## TOWN AND COUNTRY PLANNING ACT 1990

### FULL

**Reference:** H06-1103-25 **Date of Decision:** 23rd December 2025  
**Applicant:** Mr E Harris  
Hallgate House  
Hallgate  
Gedney  
Spalding  
PE12 0DA  
**Location:** Blazegate Lutton Spalding  
**Description:** Change of Use of Storage Barn to Create Residential Dwelling

DRG. No.: HARR / pl / 03

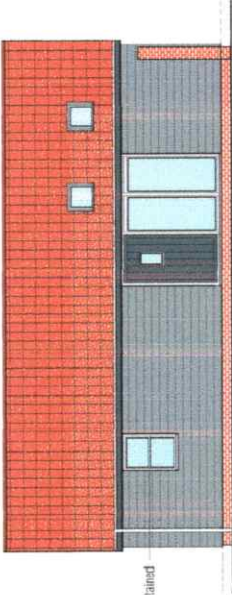
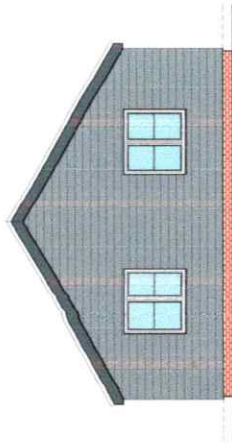
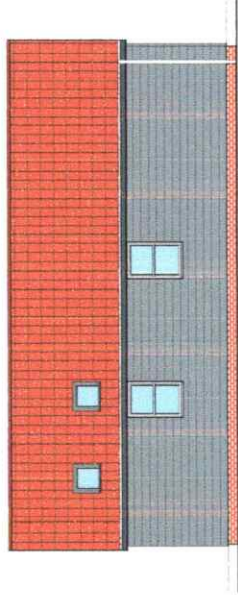
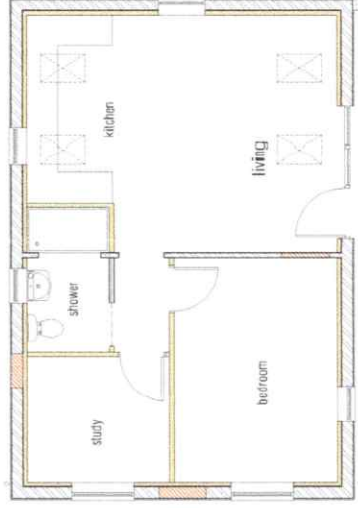
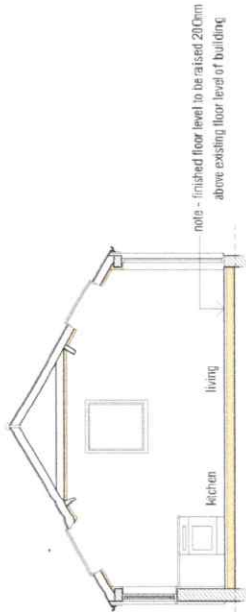
Moreover, whilst the proposed design is of more architectural merit than the existing building, it fails to be sympathetic to the existing building, due to the extent of the changes proposed. The resultant building is visually distinct from the existing building, due to the changes of external materials of the building. The proposal would therefore be contrary to criterion 4.

floor layout as existing

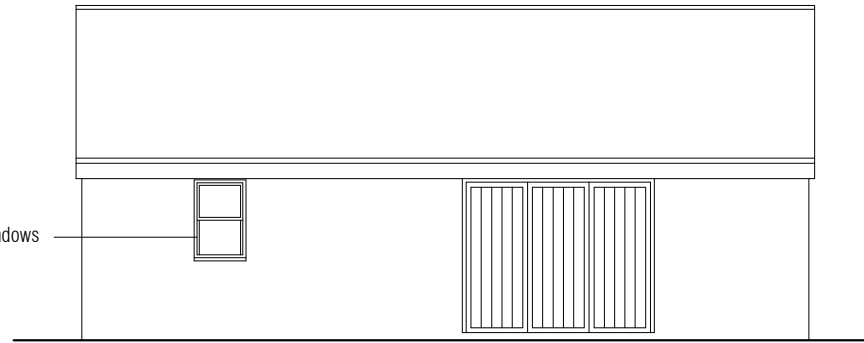
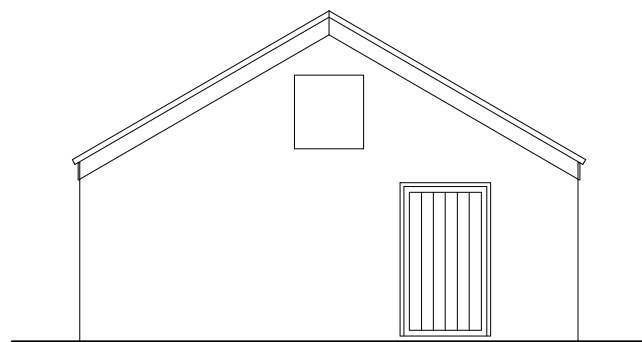
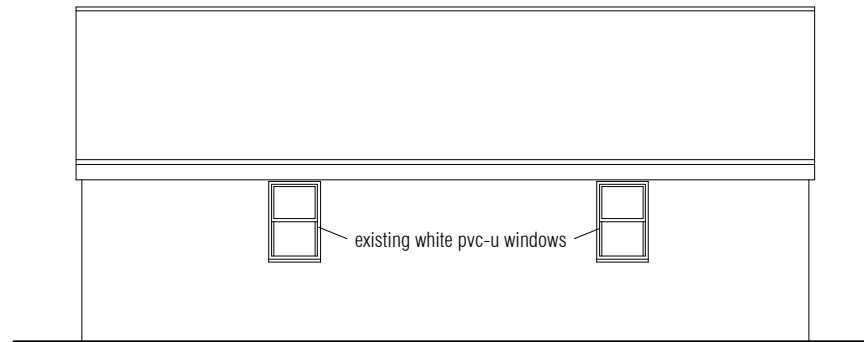
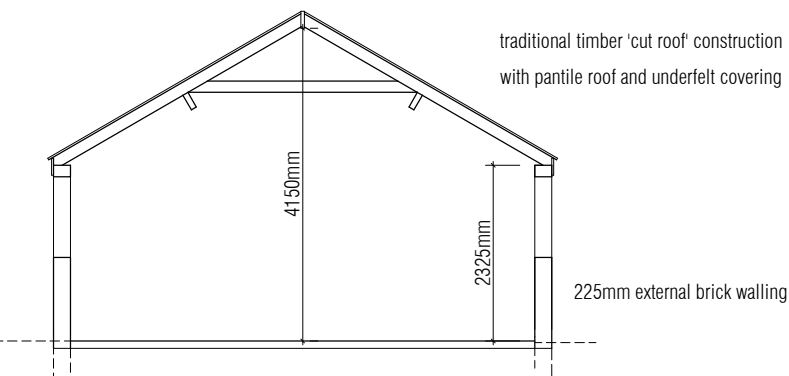
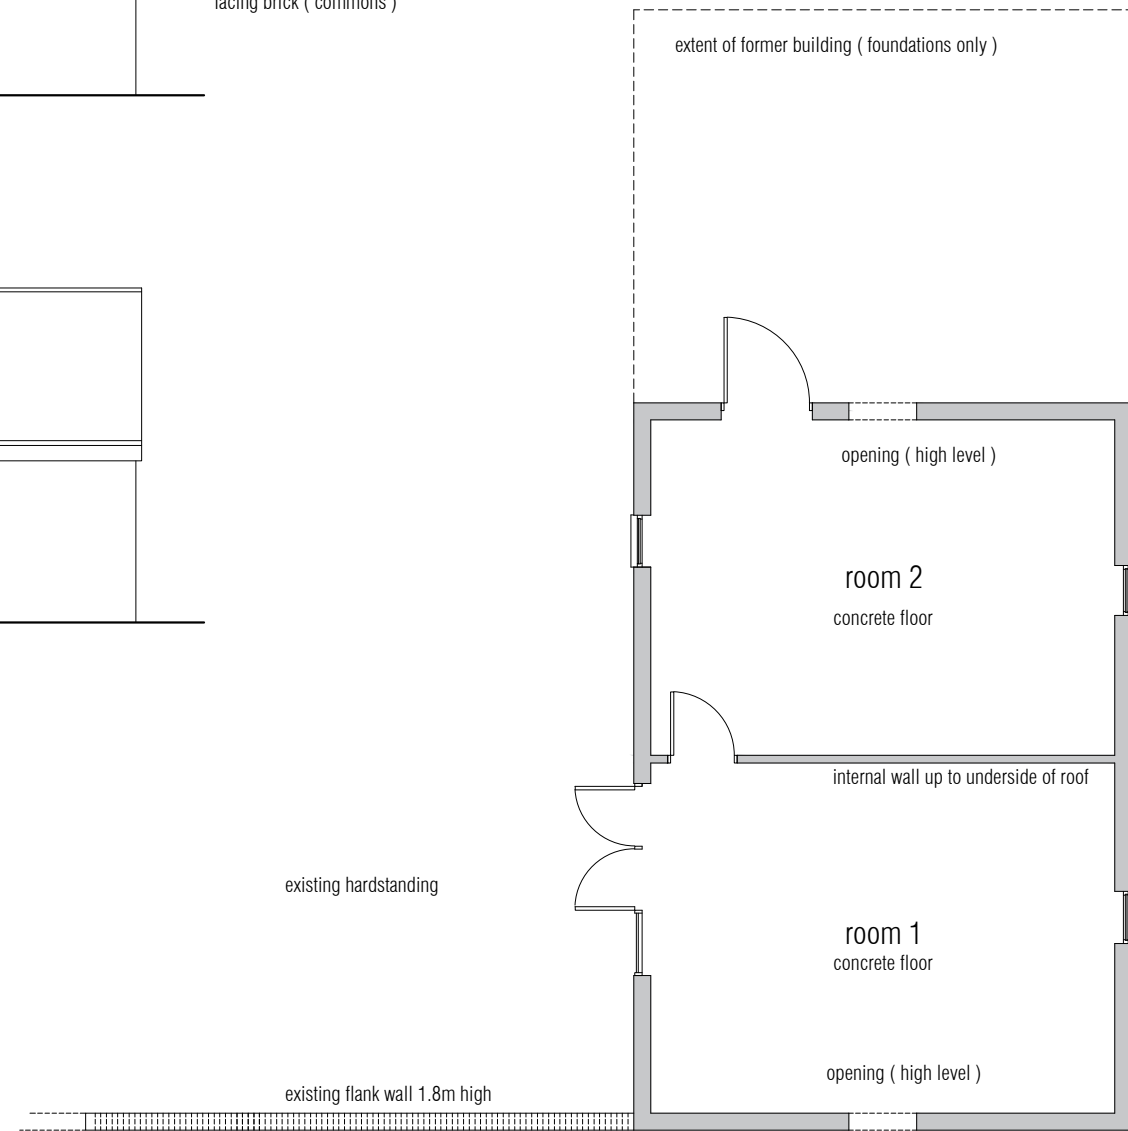
The existing building is of no architectural or historic merit to justify its retention. It is an entirely typical and utilitarian building, without any particular design features. The building is relatively modern, and is not necessarily indicative of a particular architectural or historical style. On this basis, the proposal fails to meet criterion 2.
